Drafted 29 October 2012

**Planning Application, Ribble Valley District
3/12/0702 Kingsmill Avenue, off Mitton Road, Whalley**

Project Details,
Affordable & Market Housing - Kingsmill Ave.
Plots 8 - 12

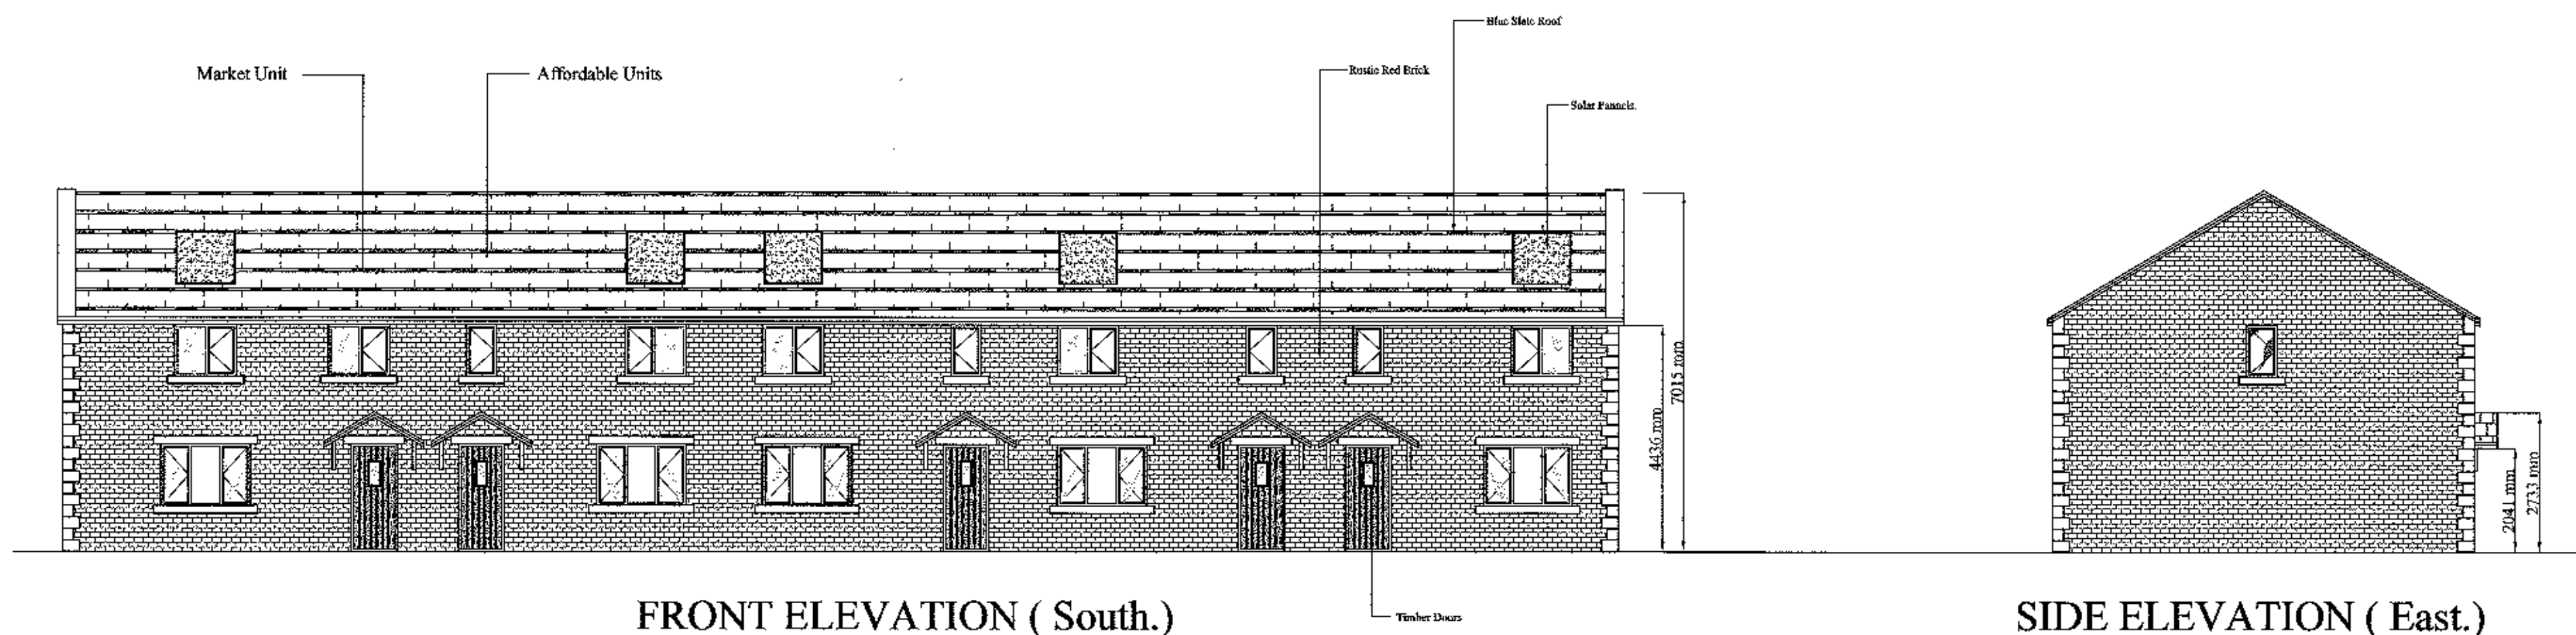
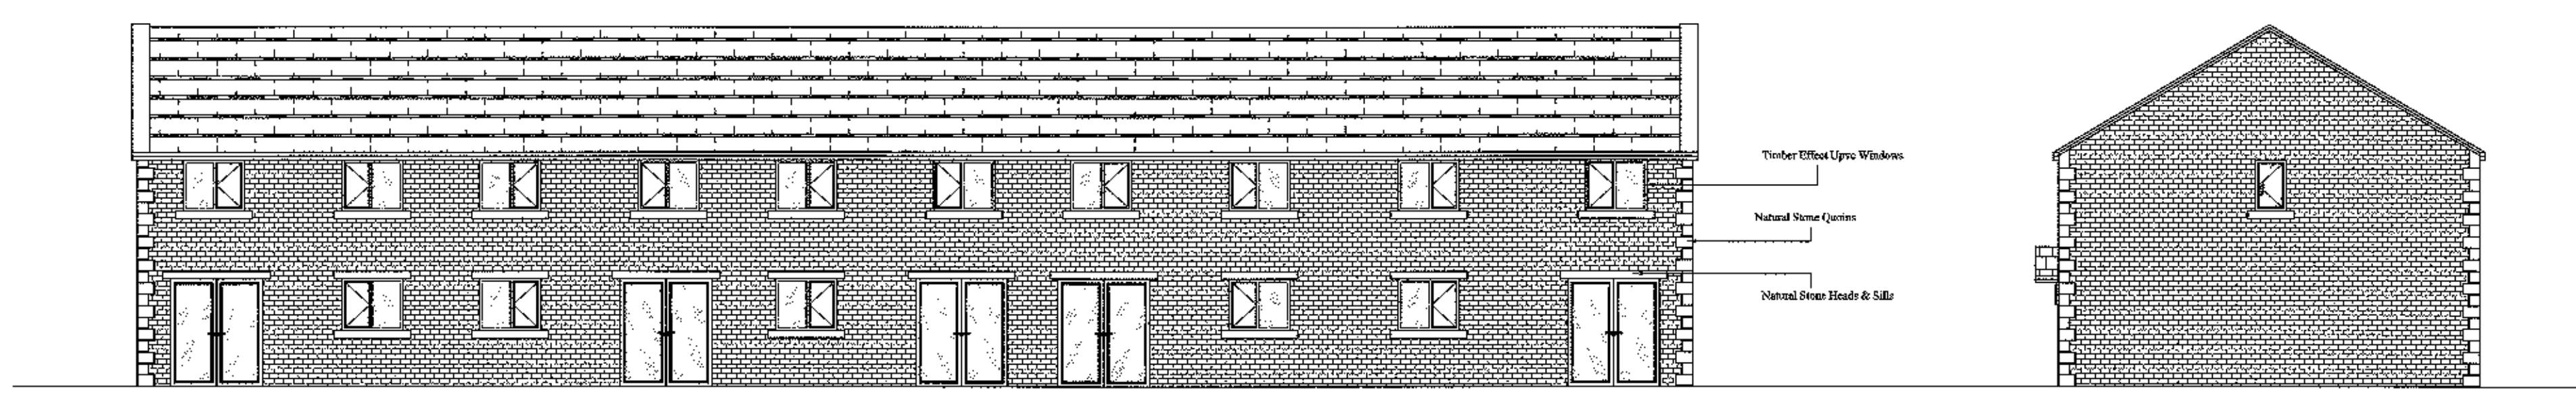
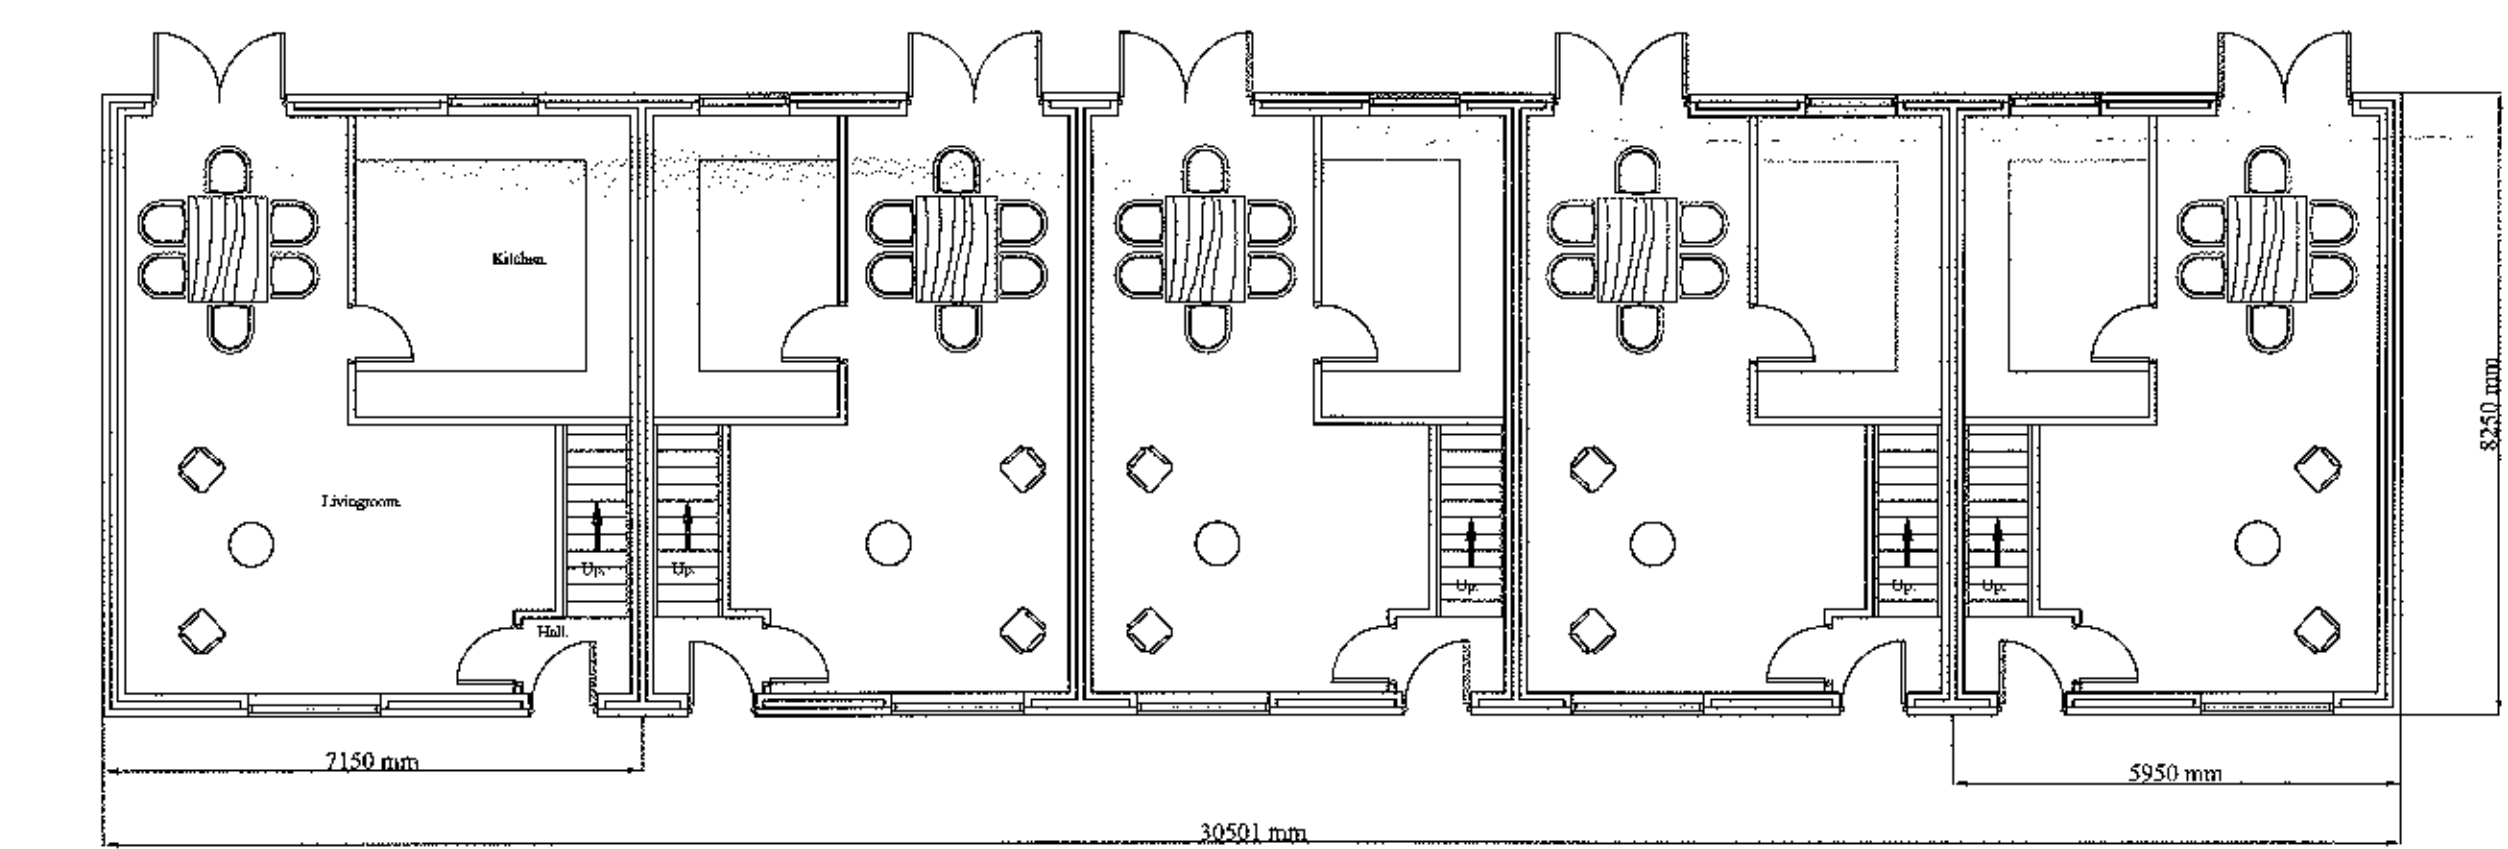
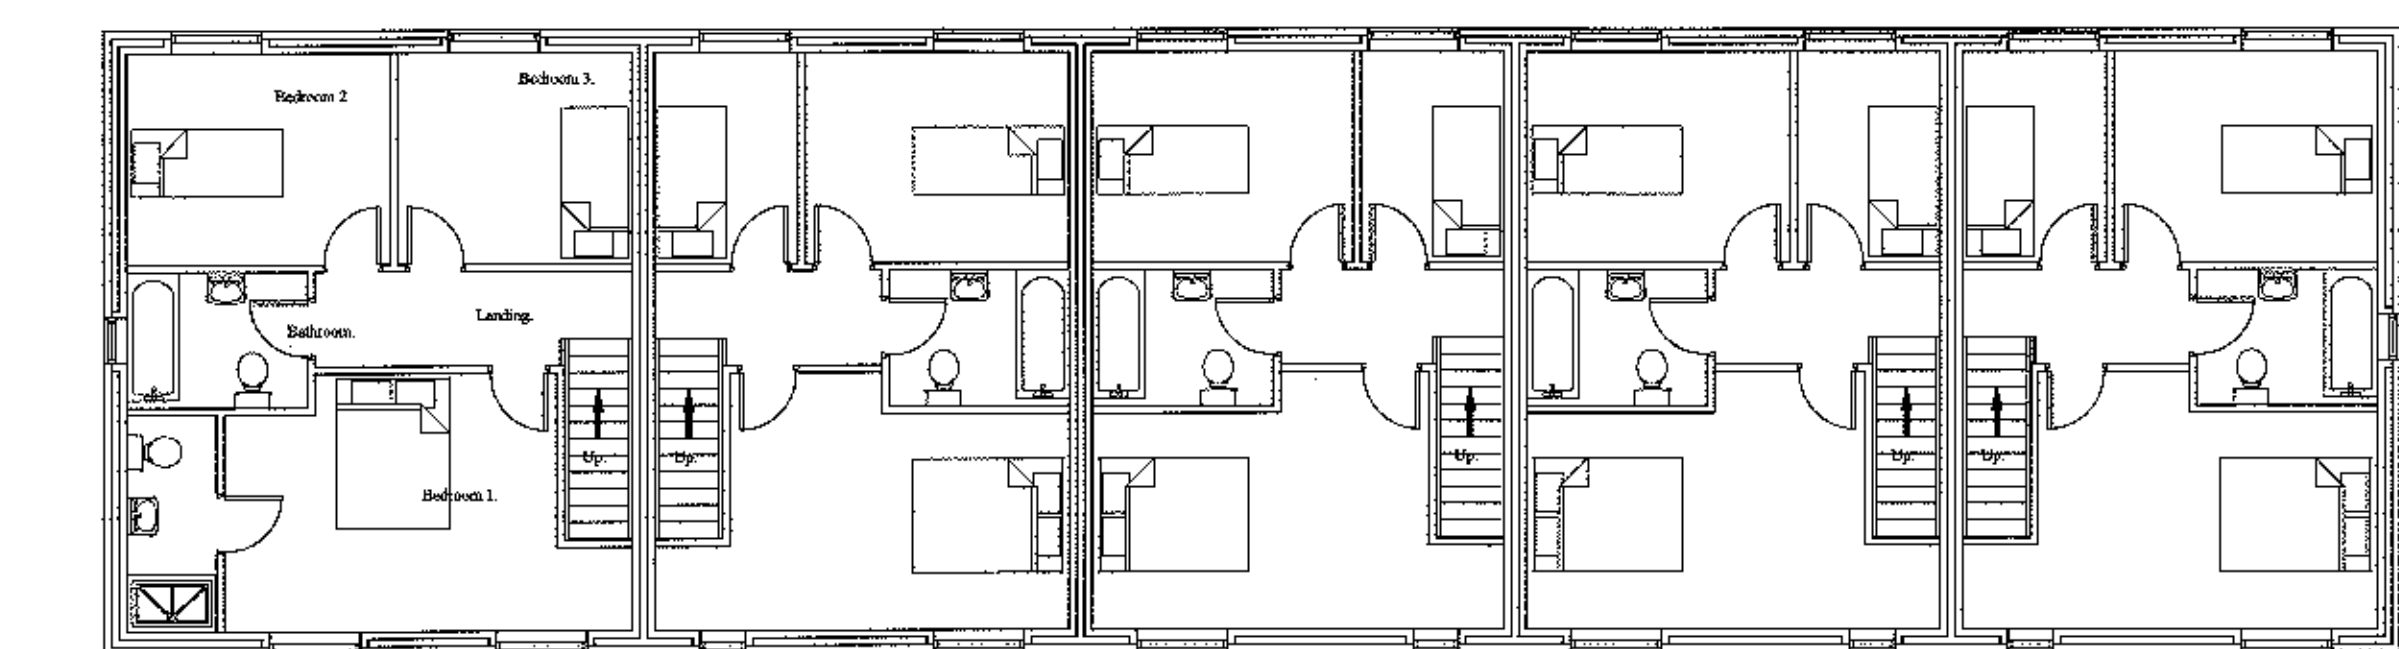
For the terraced properties, I am not satisfied that the parking arrangements shown will operate in a safe and efficient manner. If end-on parking is to be provided it needs to be identified along the back of the carriageway, not set back a significant distance. Allied to this there is no continuous footway link shown and the plan provided indicates that pedestrians would be walking to the rear of parked vehicles, within their manoeuvring space.

I would suggest that a continuous footway link should be provided to the front of the terrace properties and that the parking spaces are aligned to the back of the edge of carriageway.

In addition, there should be 8 spaces provided for the 5 unit terrace; 2 for the 3 bedroom market property and 1.5 for each of the four 3 bedroom affordable units. This will more accurately reflect the relevant provisions for this independent development location. This level of provision will provide sufficient parking off the active carriageway for the anticipated residential requirements of these properties.
